# CITY OF ALBUQUERQUE

September 20, 2018

**Re: Yale Apartments**  
**2017 Yale SE Albuquerque NM 87106**  
**Traffic Circulation Layout**  
Engineer's/Architect's Stamp **05-07-18** (L15D022)

TRAFFIC CIRCULATION PLAN

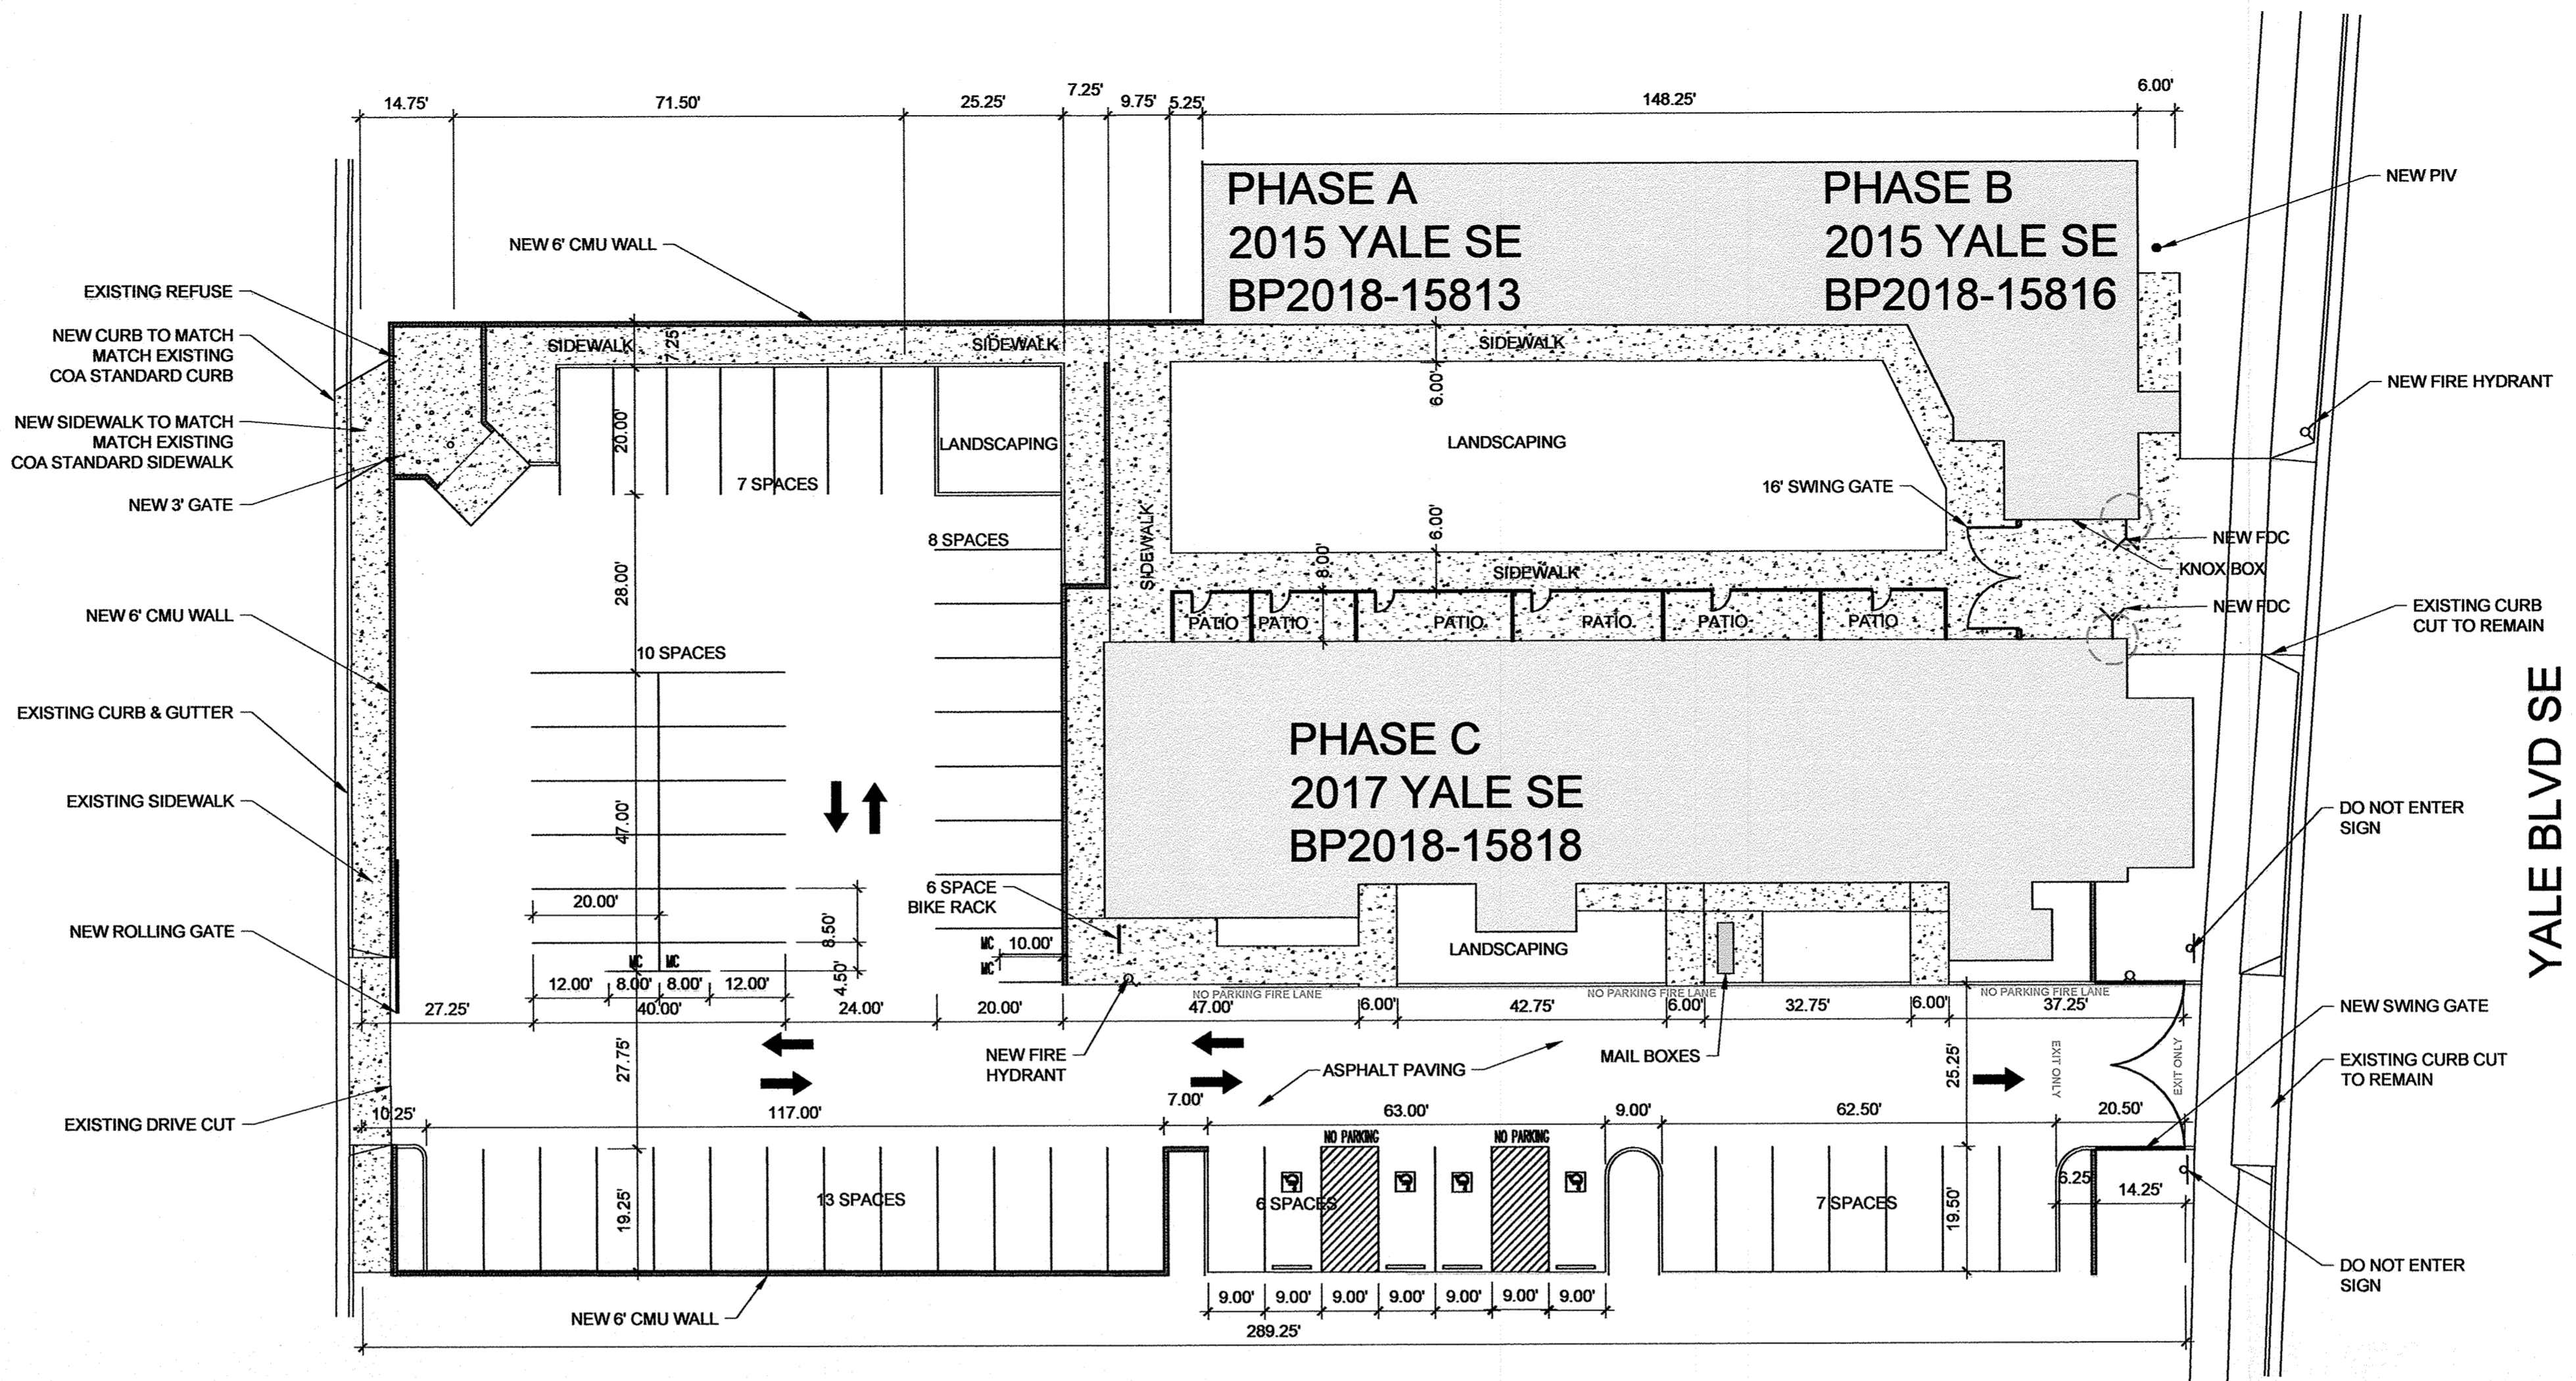
1. Unused curb cuts must be replaced with sidewalk and curb & gutter. A build note must be provided referring to the appropriate City Standard drawing. **Would you please justify your reason to keep the Yale Blvd's curb cut?**
2. Service vehicle and/or refuse vehicle maneuvering must be contained on-site.
